HAY CREEK VALLEY

PRELIMINARY PLAN

HAY CREEK VALLEY SUBDIVISION
 PRELIMINARY PLAN

EL PASO COUNTY, CO
 APRIL 2023

GENERAL NOTES & DETAILS

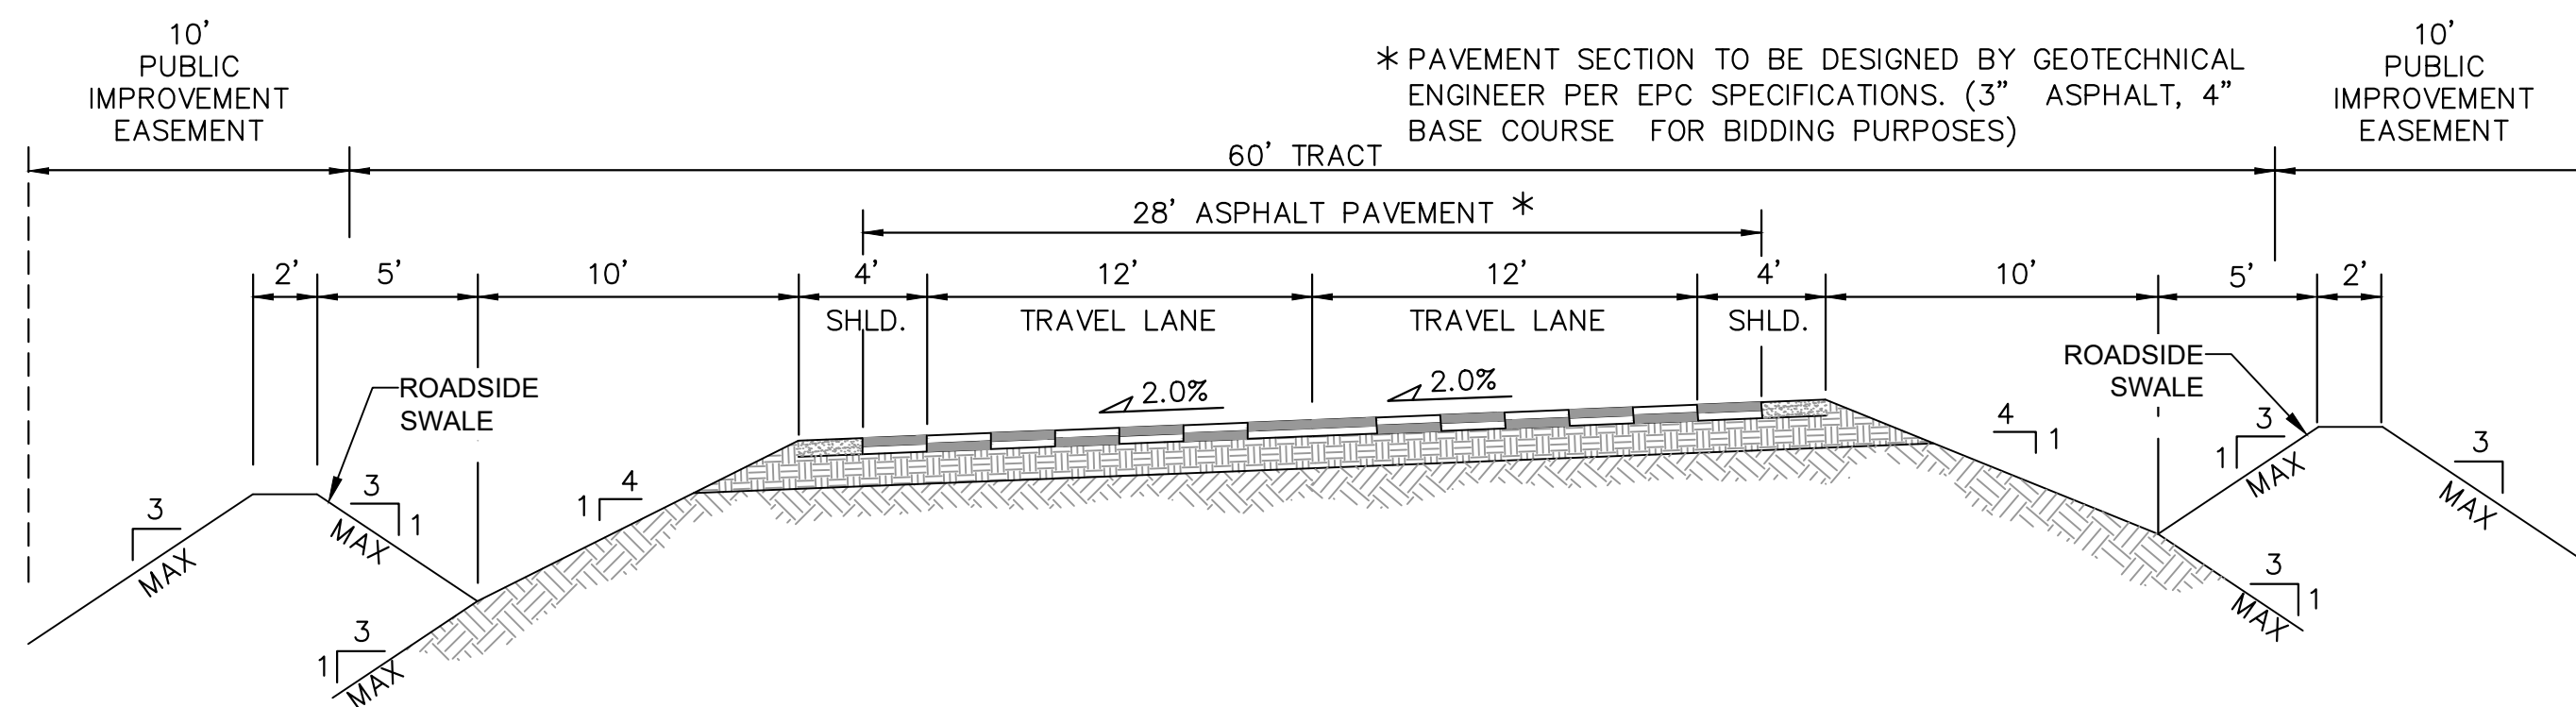
base add design and posted speed.

Update the cross section to match the drainage plan. The proposed drainage map shows the entire road is superelevated and sloping to the north with no crown at centerline.

If that is correct then a deviation request from ECM 2.3.3.D.2 is required. "superelevation is not permitted on roadways with design speeds less than 50 mph."

**TRACT MAP &
 SHEET INDEX**

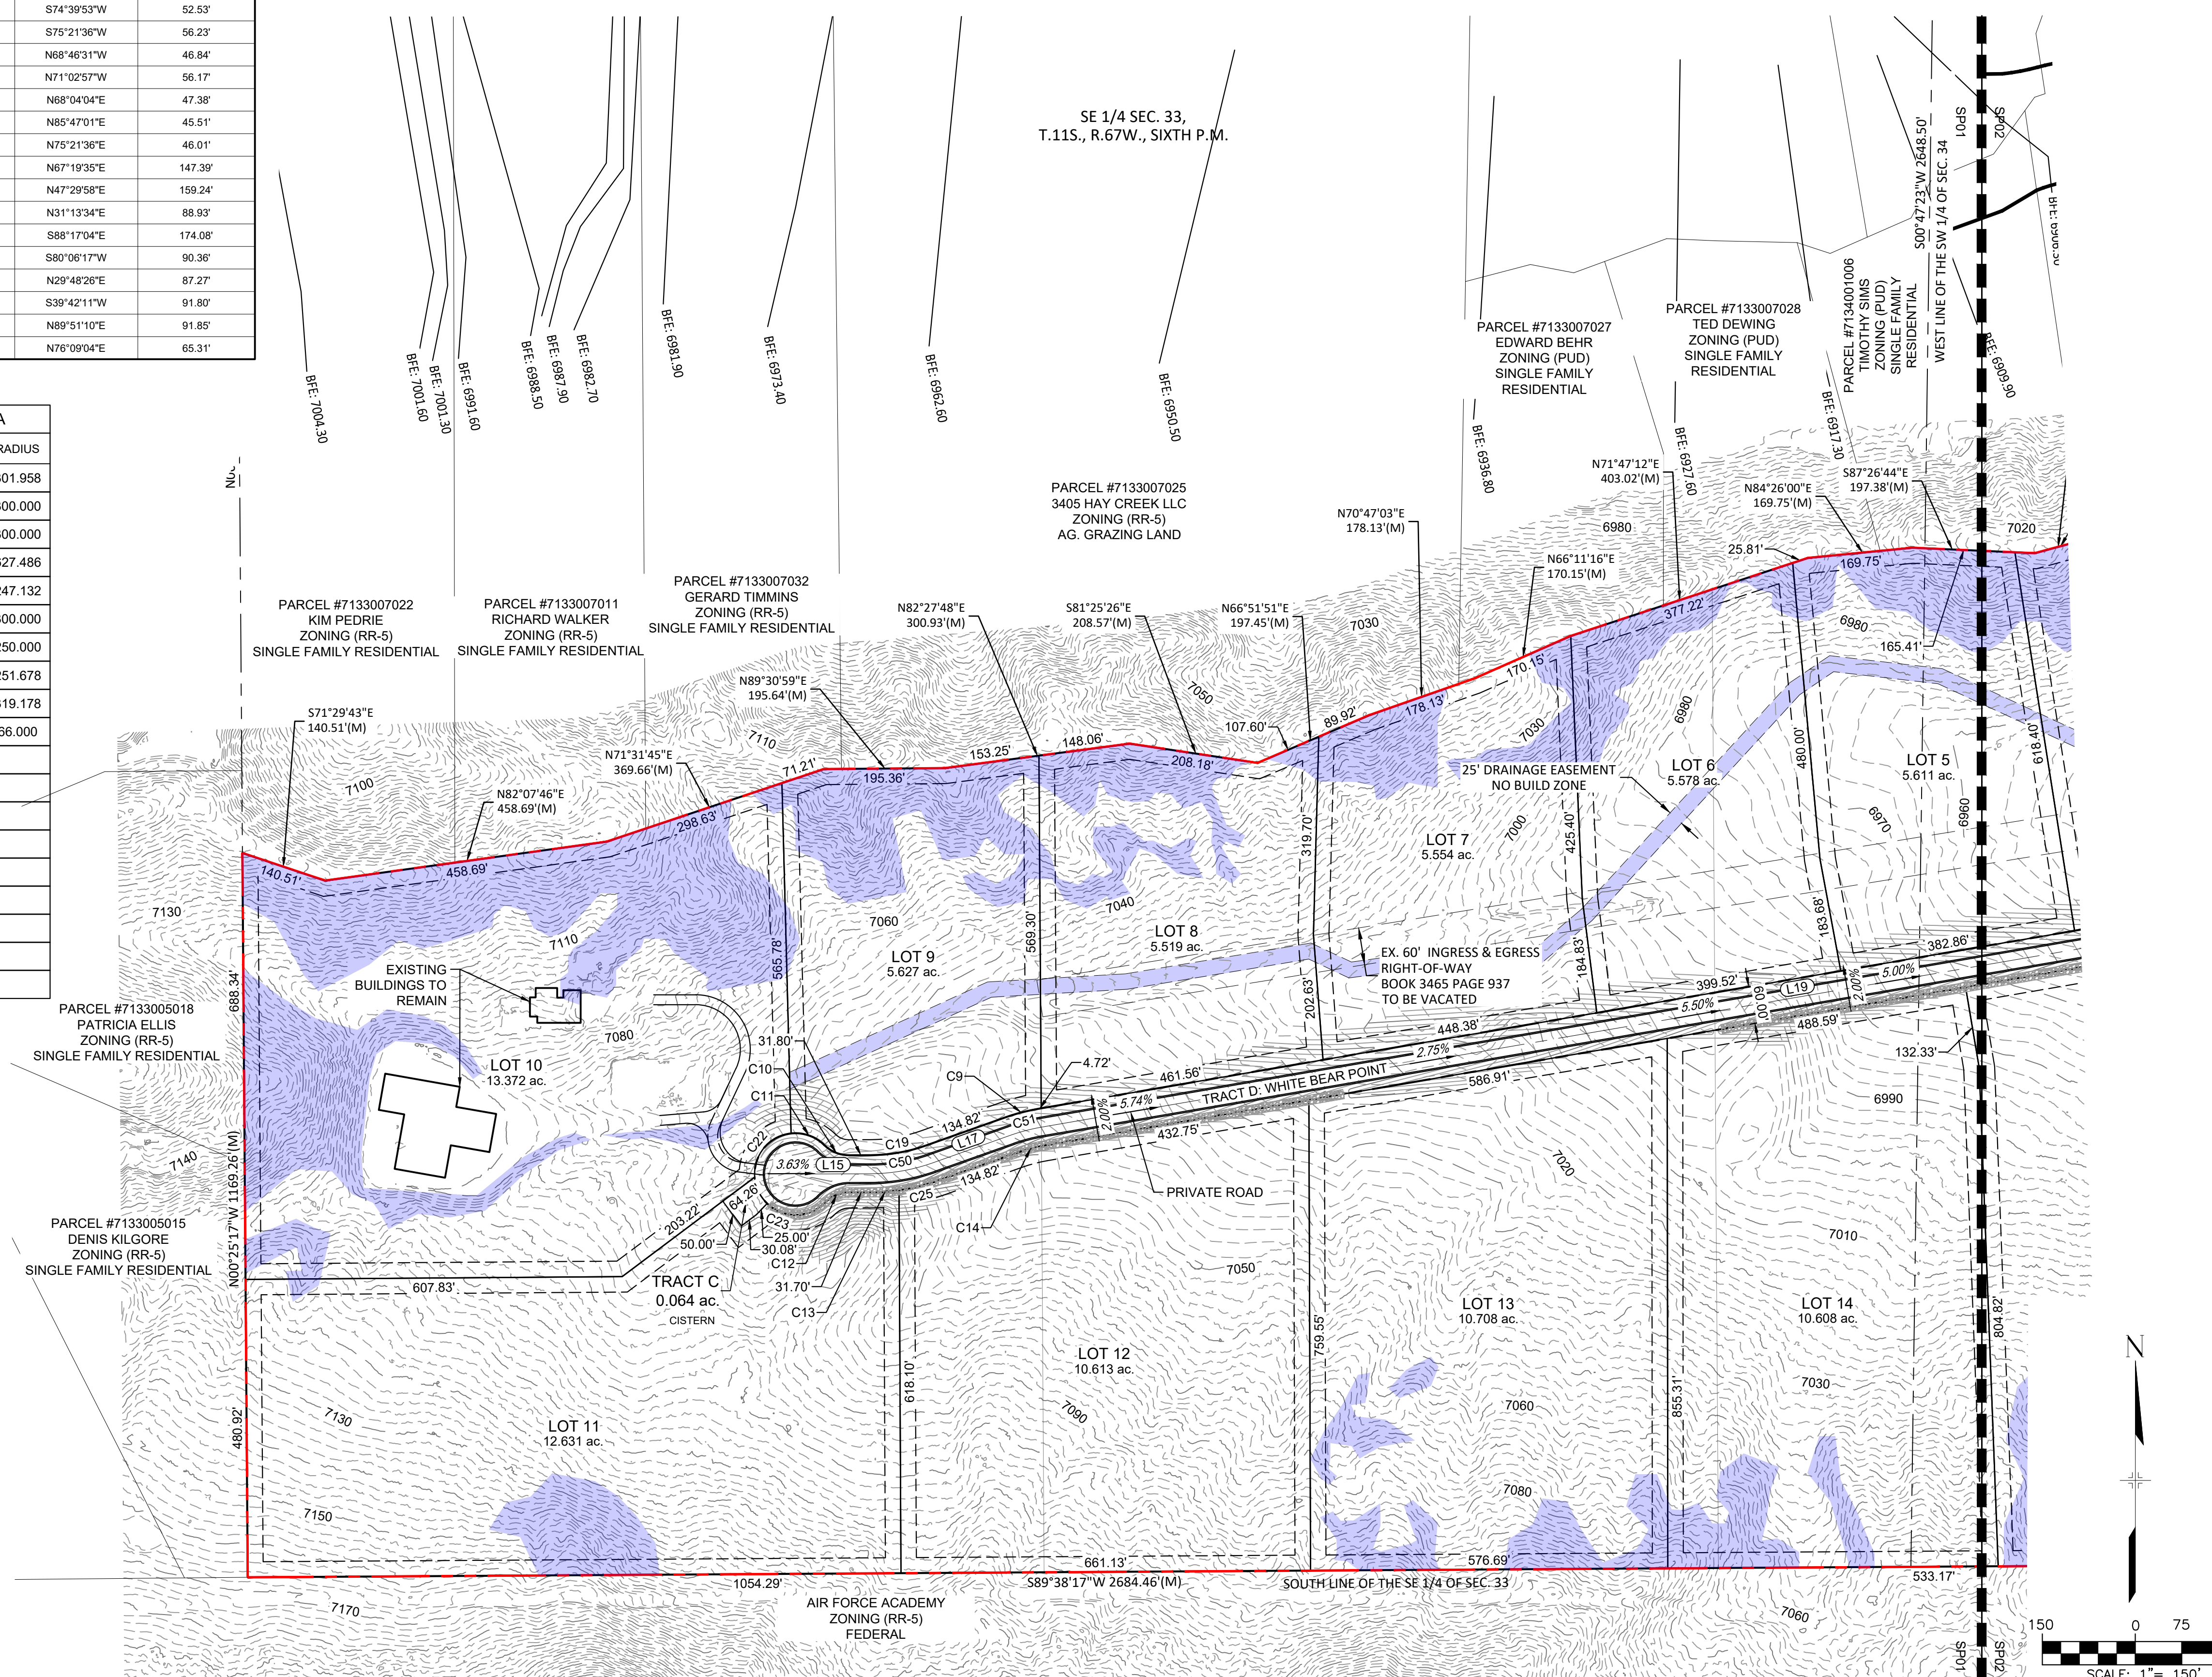
Identify hazards that are located on each individual lot
